Consultation Response from KC, Conservation & Design
2022/91284 Greenhead College, Greenhead Road, Huddersfield, HD1 4ES

Discharge of conditions 16 (Ecological Design Strategy), 17 (external materials), 27 (Noise Assessment) and 31 (Hard and soft landscaping) of previous permission 2021/93674 for partial redevelopment of Greenhead College including demolition and making good, erection of 2 and 4 storey buildings, reconfiguration of parking and access arrangements, reconfiguration of sports provision and other associated external works (Within a Conservation Area)

Date Responded: 20.5.22
Responding Officer: Sue Brooks
Responding Ref:

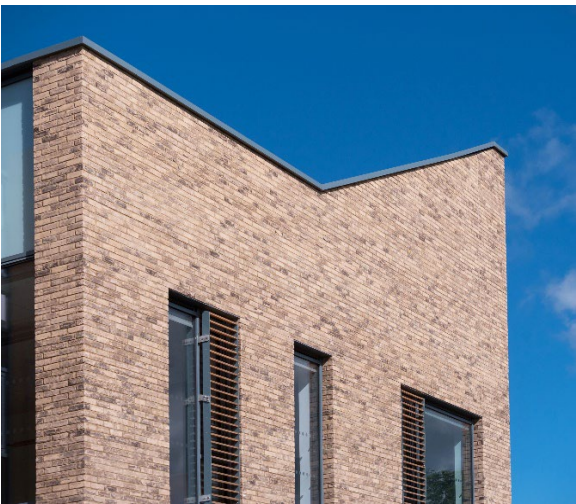
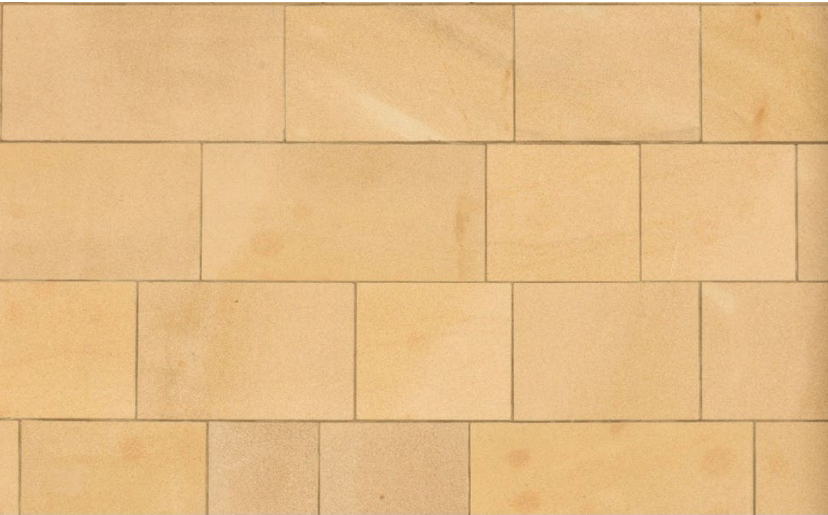
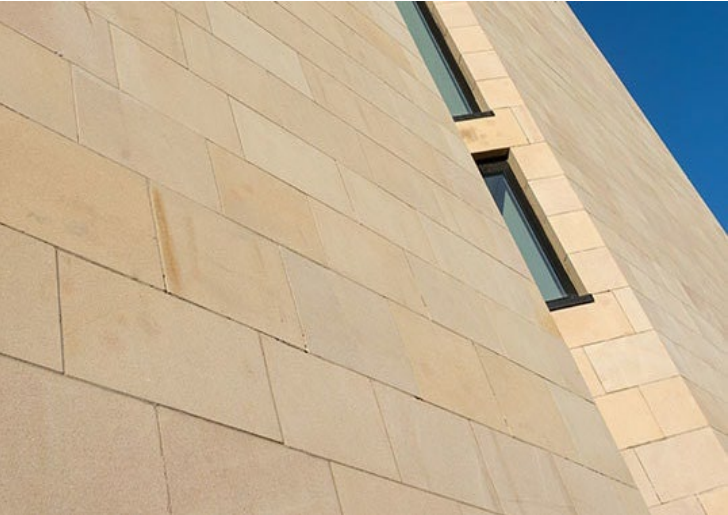
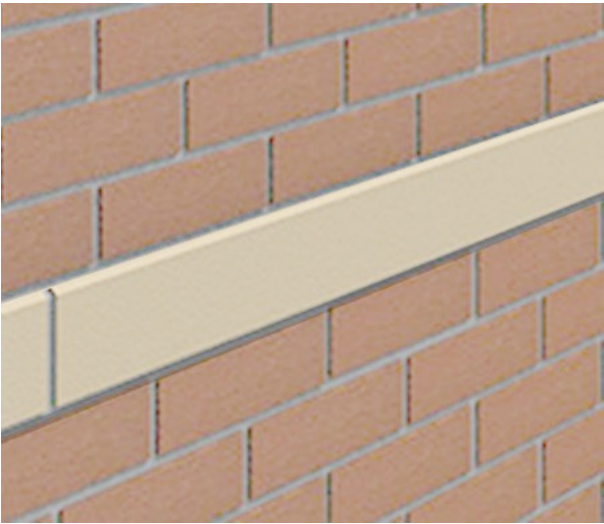
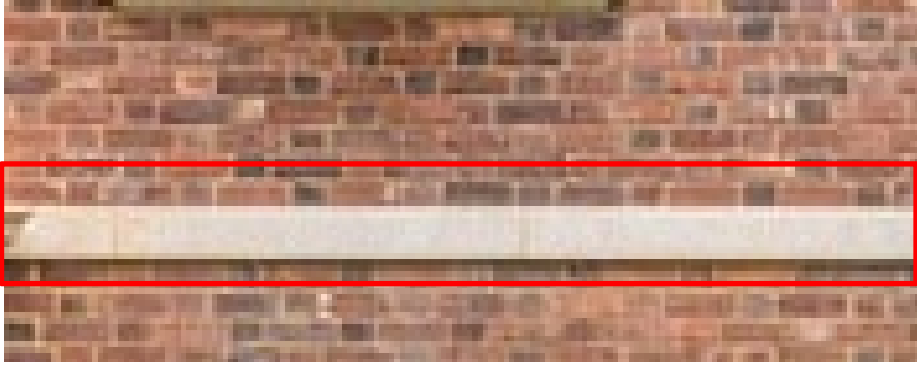
To enable the proposed materials to be understood in context with each other and the adjacent school building we would recommend that samples are provided on site as it is unclear from the images how they will appear in context with each other and the existing buildings.

Detail 14 - Typical Block Paving Detail.

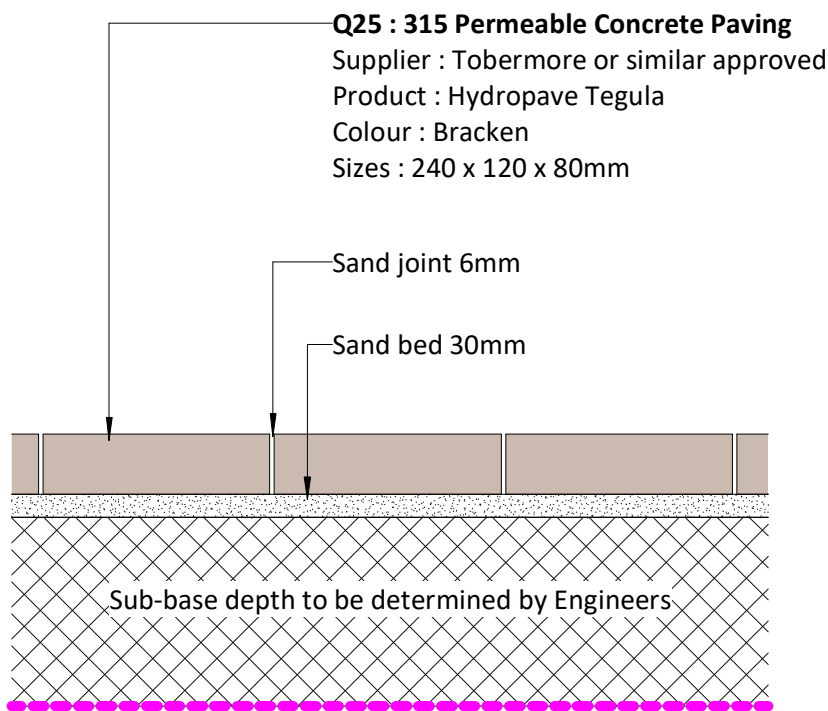
We have concerns about the proposed paving to the south of the building:

- Permeable block paving, cedar colour or similar.

A more natural stone paving would be preferable to this area as it forms the main focal point for the new development, with the main entrances of the existing school and new building located in this area. The paving materials should complement and take reference from the predominant colour and materials of the buildings, as referred to in the Design and Access Statement. We would recommend that a buff-coloured paving slab is proposed, preferably in natural stone, as indicated on the 3D Exterior View 1 within the Design and Access Statement.
